Application No: A/24/21/PL
Site Address: Land South of Water Lane Angmering
Description of works: Erection of a temporary sales cabin with 4 parking spaces and associated landscaping. CIL Zone 1 - This application is zero rated as temporary building.

Thank you for your internet representation made on 16th March 2021 which has been recorded as an objection with the comments as follows:

I am writing to register my objections to the proposed planning application A/24/21/PL. My Grade II property is directly opposite the proposed entrance to the sales cabin.

Project  
**Land at Water Lane,  
Angmering, West Sussex.**  
Drawing Title  
**Sales Area Layout**

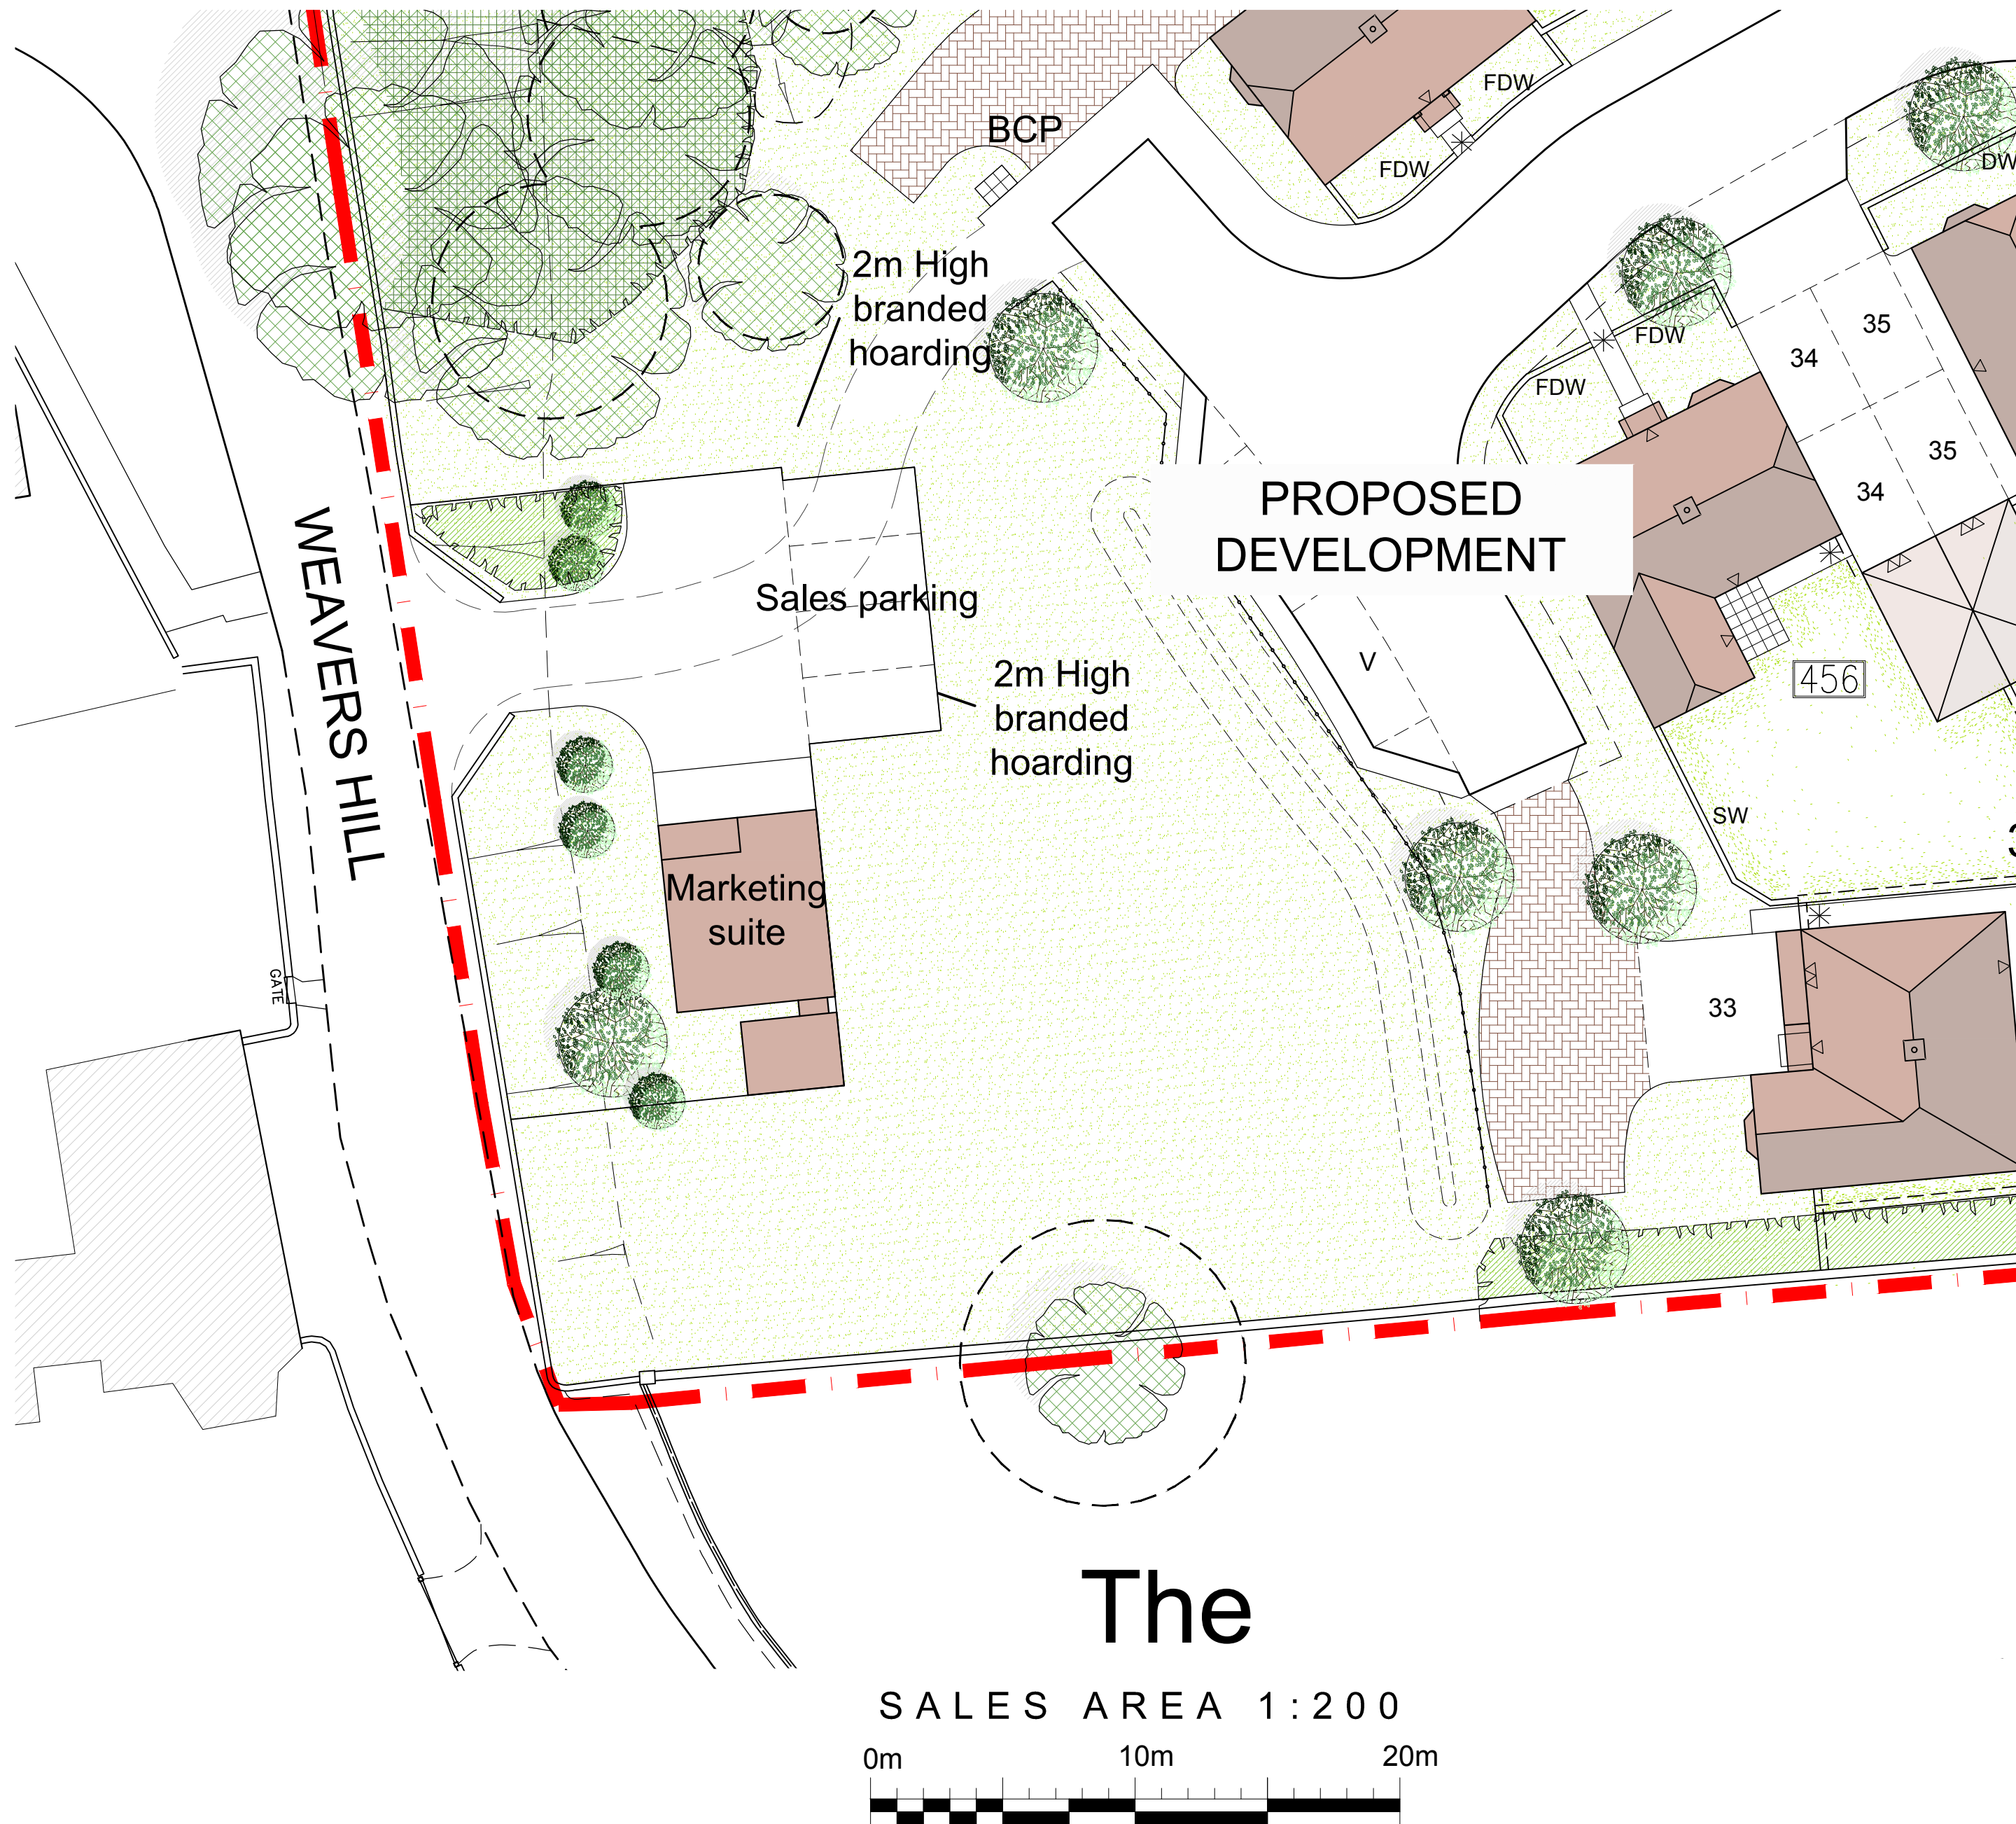
The section of flint wall which is going to be demolished for the entrance to the sales cabin is within the Angmering Conservation Area (as shown on Arun District Council plan dated 2014) and is of historic interest, worth preserving and, a modern sales cabin which is designed to attract attention for a commercial purpose, will have a negative and adverse impact to this area. The plan will have a detrimental effect on the character of the conservation area with two Grade II properties, one opposite the site and one adjacent to the site. The sales cabin is to market a residential development consisting of at least 150 properties, a multiple year project, so although the plan states the sales cabin will be a temporary arrangement, it does not give a specific time scale and is highly likely that the sales cabin will be in place for multiple years.

The entrance of the proposed sales area has been placed on the brow of Weavers Hill, a narrow lane that has multiple blind spots. The scale of the development will attract constant incremental traffic for multiple years, entering and exiting the sales cabin site on a pinch point of Weavers Hill, close to a blind spot on the lane. Weavers Hill is used by pedestrians, both residents and leisure walkers enjoying the character of the conservation area, there is no pedestrian pavement in the area that the sales cabin is proposed to be located and walkers use the lane with motor vehicles. Clearly this sales cabin will adversely compromise the highway safety for pedestrians and other road users for multiple years.
